**Kevin Cox**  
**Crime Prevention Design Advisor**  
Thames Valley Police Headquarters South  
Oxford Road  
Kidlington  
Oxfordshire  
OX5 2NX

REF: 23/02523/F

Location: Kirtlington Village Hall South Green Kirtlington  
OX5 3HJ

03 November 2023

Ground Floor Plan 1:100  
Scale 1:100

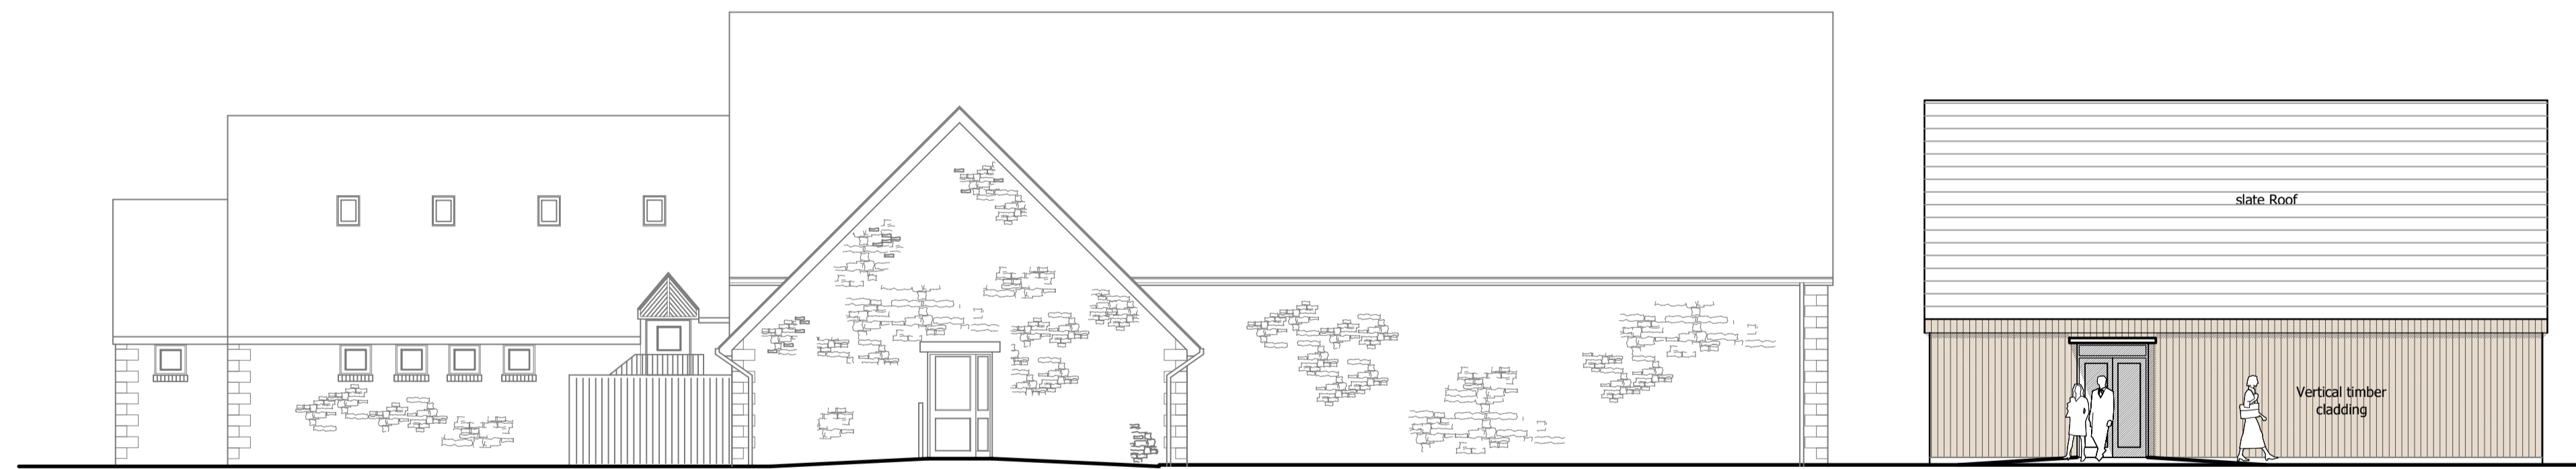
- It is unclear from plans how post deliveries will be managed outside of the buildings opening hours. The building should facilitate postal deliveries either via secure external post box certificated to DHF TS009, or via through-the-wall post box into a container also rated to protect against arson attacks.
